**From:** Nolan, Chris <Chris.Nolan@lancashire.gov.uk>  
**Sent:** 13 October 2017 13:34  
**To:** Robert Major; planning  
**Cc:** LHS Customer Service  
**Subject:** D3.2017.0941 - 26 Holden St, Clitheroe

Planning Application No: 3/2017/0941  
Grid Ref: 374676 441901

Proposal: Two storey extension to side including garage at ground floor level and extension of teaching space at first floor, with single storey toilet and washing/storage area to the rear leaving access from the neighbouring rear yard to the front of the street (resubmission of planning application 3/2016/1169).

Location: 26 Holden Street Clitheroe BB7 1LU

**Proposed Site Plan 1:200**

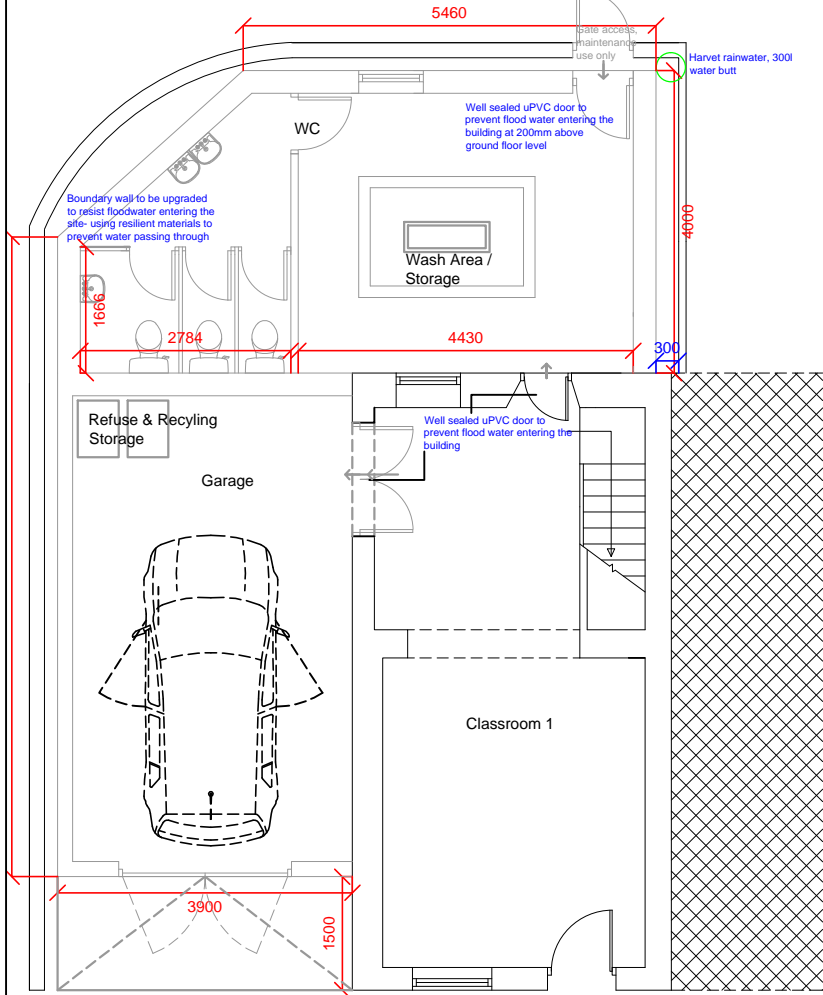
With regard to the above planning application. In principal I would not have highway concerns with regard to the extension to No 26 Holden Street with exception to ensuring that the storage of household waste is confined to the garage space and this is not placed on the highway for any other reason than the periodic collection.

Proposed Front Elevation

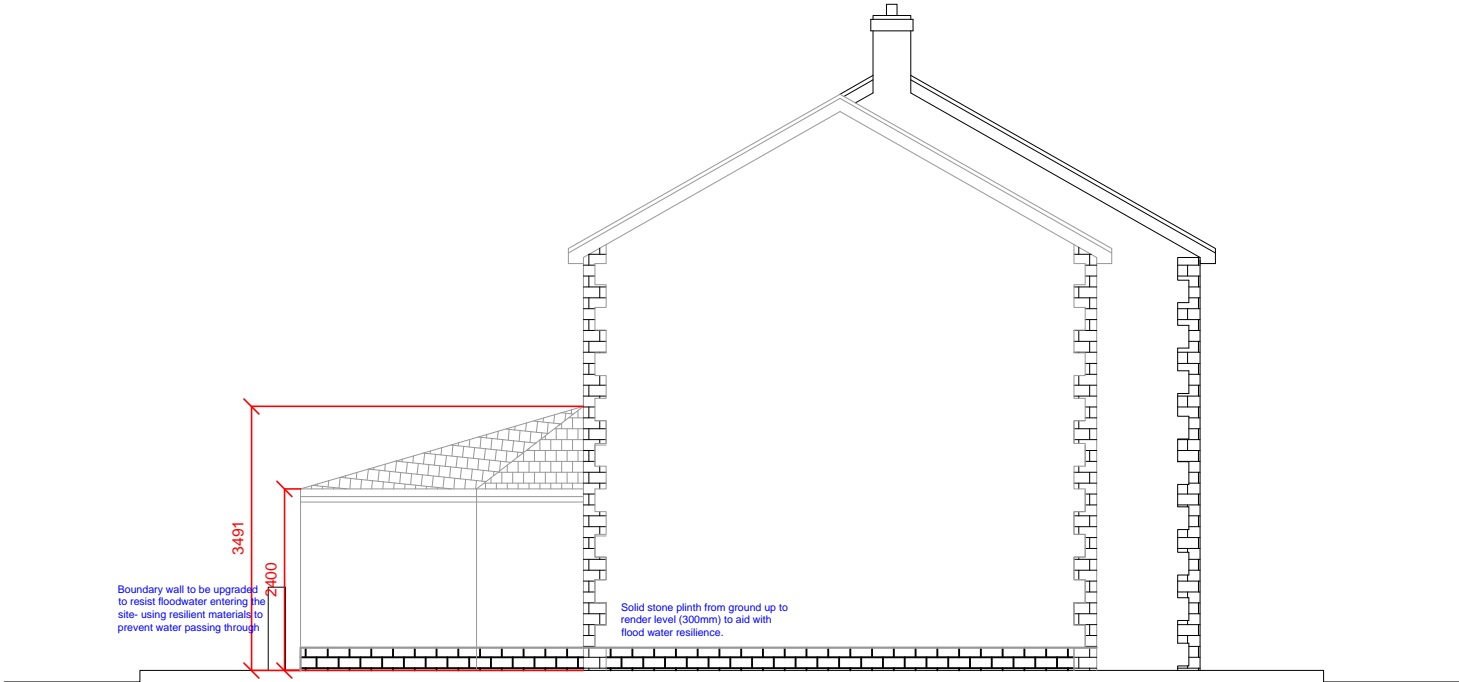
1. This consent does not give approval to a connection being made to the County Council's highway drainage system.
2. In order to construct the external walls, the building construction work will extend into the highway and consequently this office should be notified of the proposed works before the development is commenced. Before commencing any construction work you must contact the Lancashire County Council, Street Works [lhsstreetworks@lancashire.gov.uk](mailto:lhsstreetworks@lancashire.gov.uk) or 01772 533433
